Our Ref: EN010098

## **Planning Act 2008 (as amended) – Section 51**

### **Application by Ørsted Hornsea Project Four Limited for an Order Granting Development Consent for the Hornsea Project Four Offshore Wind Farm**

#### **Advice following issue of decision to accept the application for examination**

Onshore Crossing Schedule
Document no: HOW040419
Created by: XDAOO
Checked by: WATTS
Accepted by: KELLY
Approved by: JAMIB

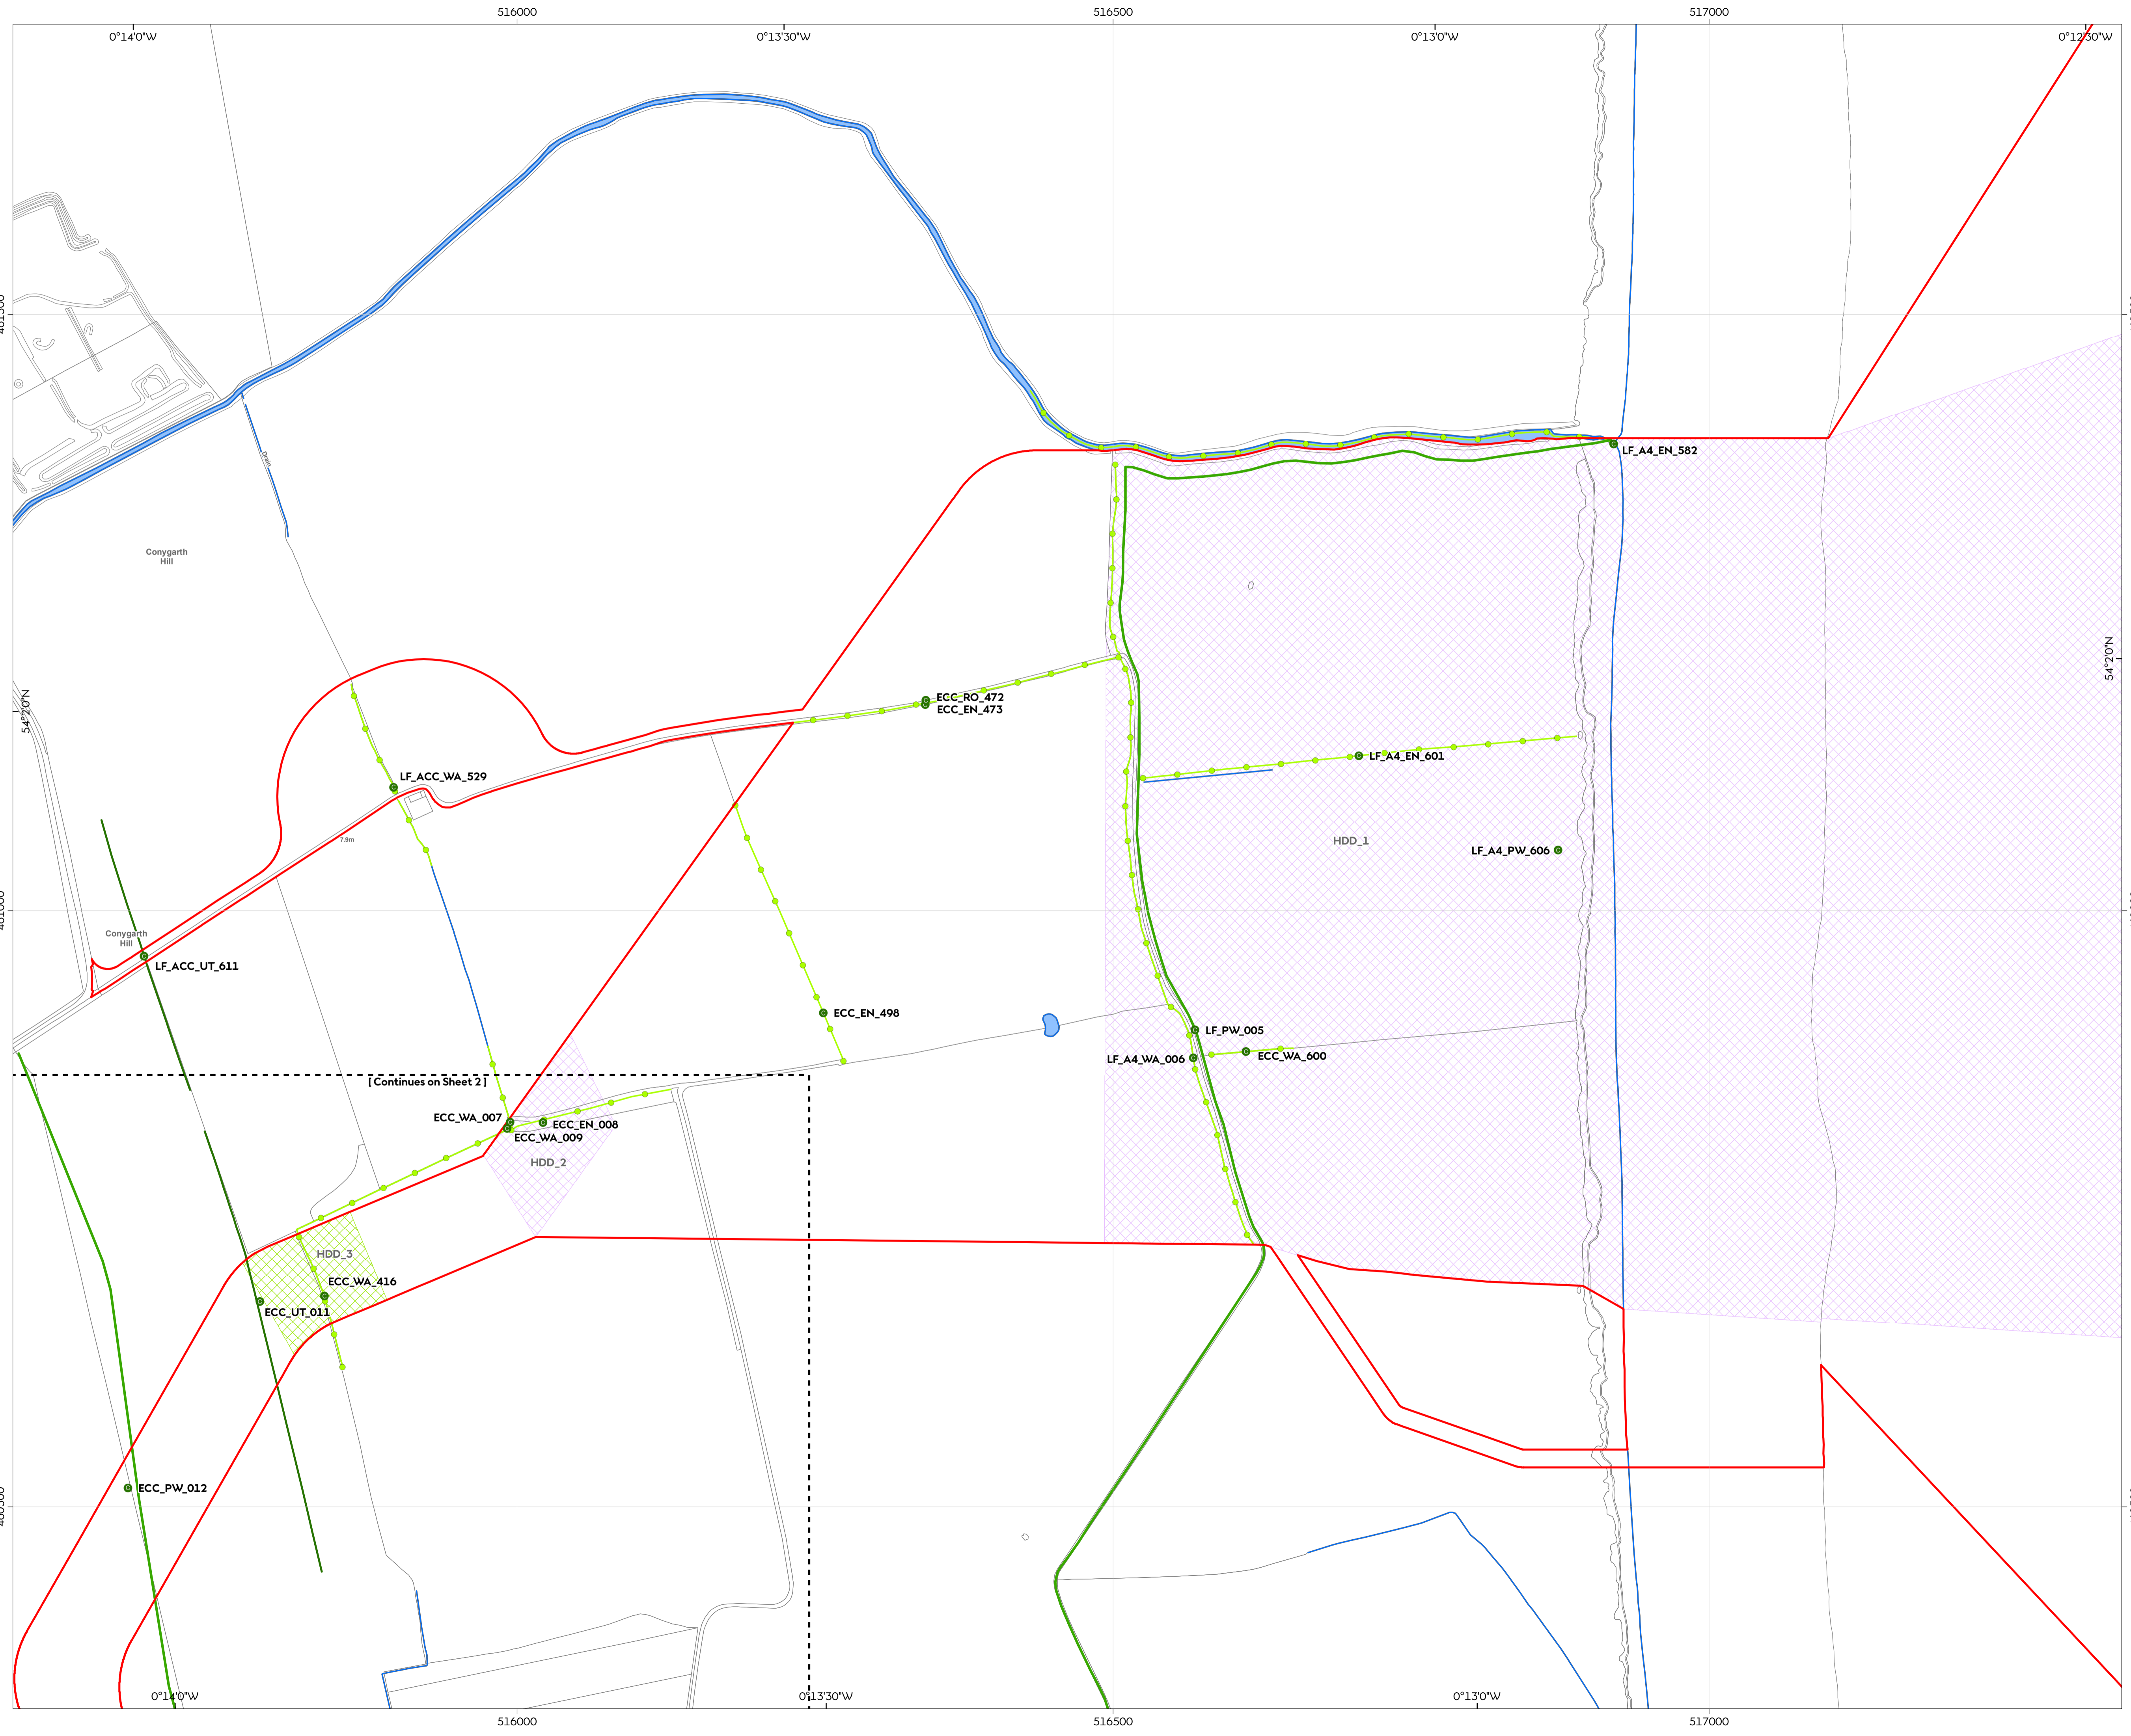
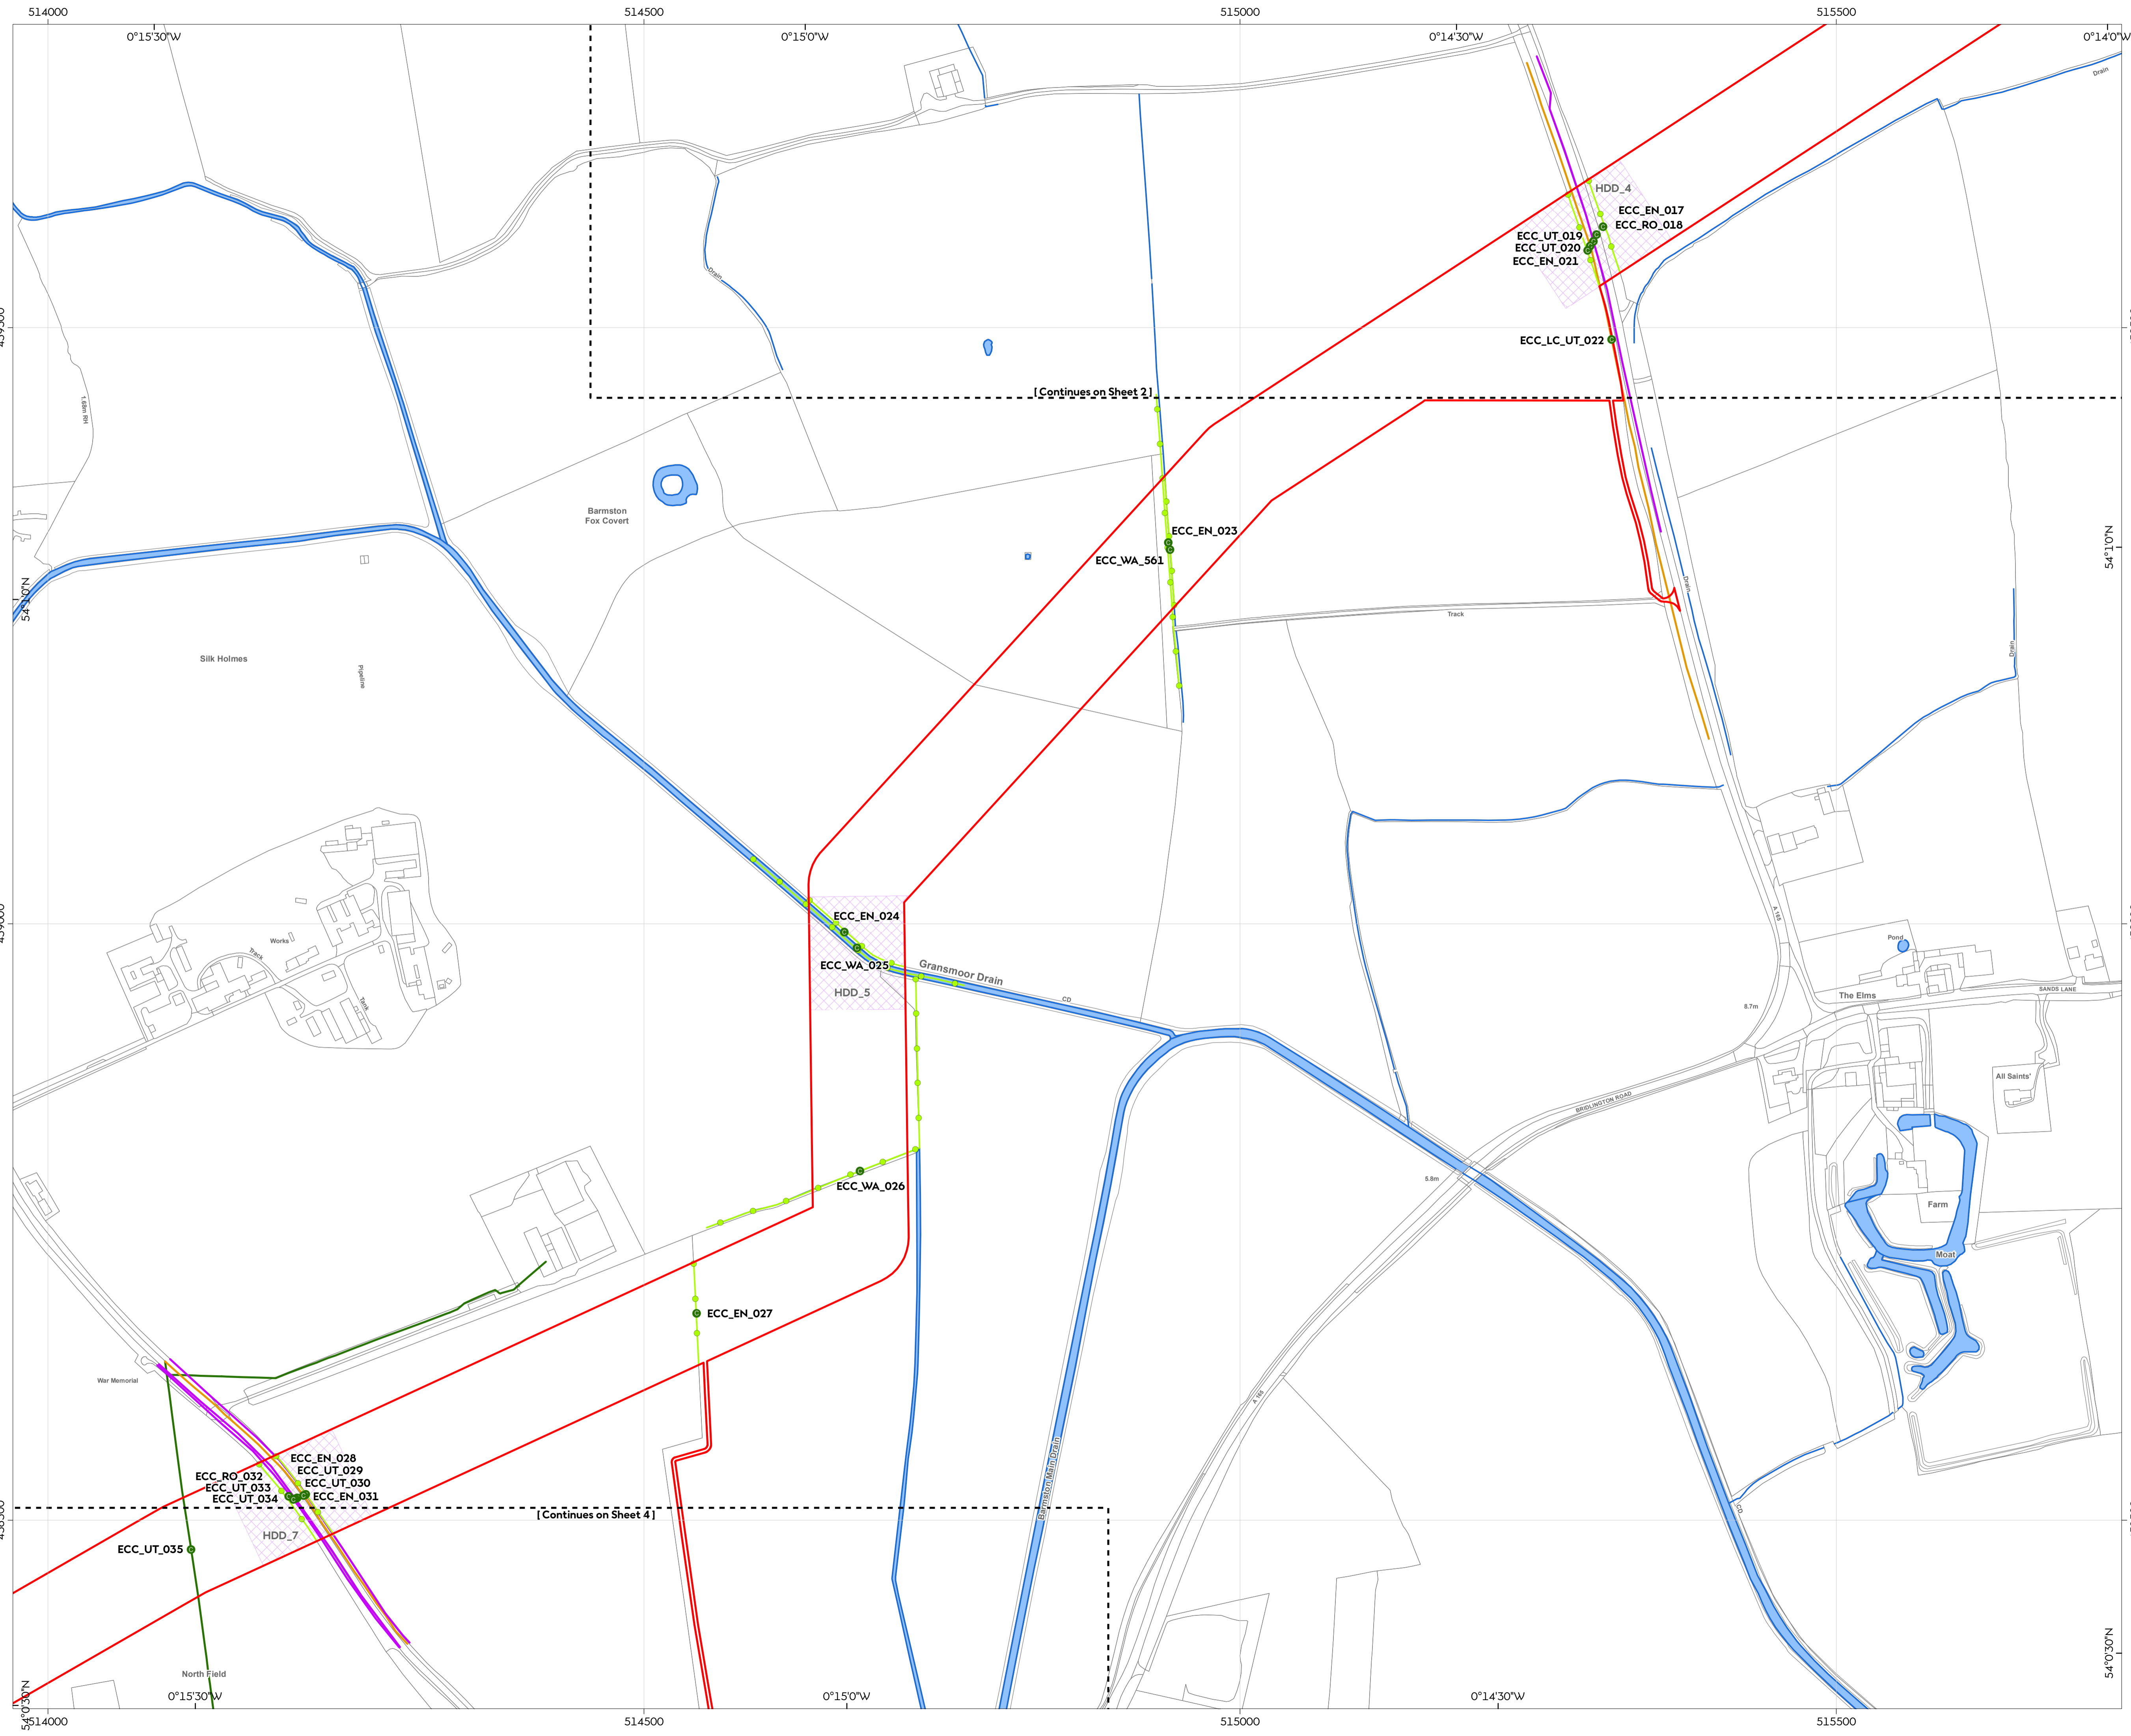
The location of all HDDs is presented in the Onshore Crossing Schedule (Doc A4.4.2). However, this document is not referenced within the draft DCO (Doc C1.1). If HDD is proposed to mitigate any environmental effects the Applicant is advised to ensure that its delivery is secured.
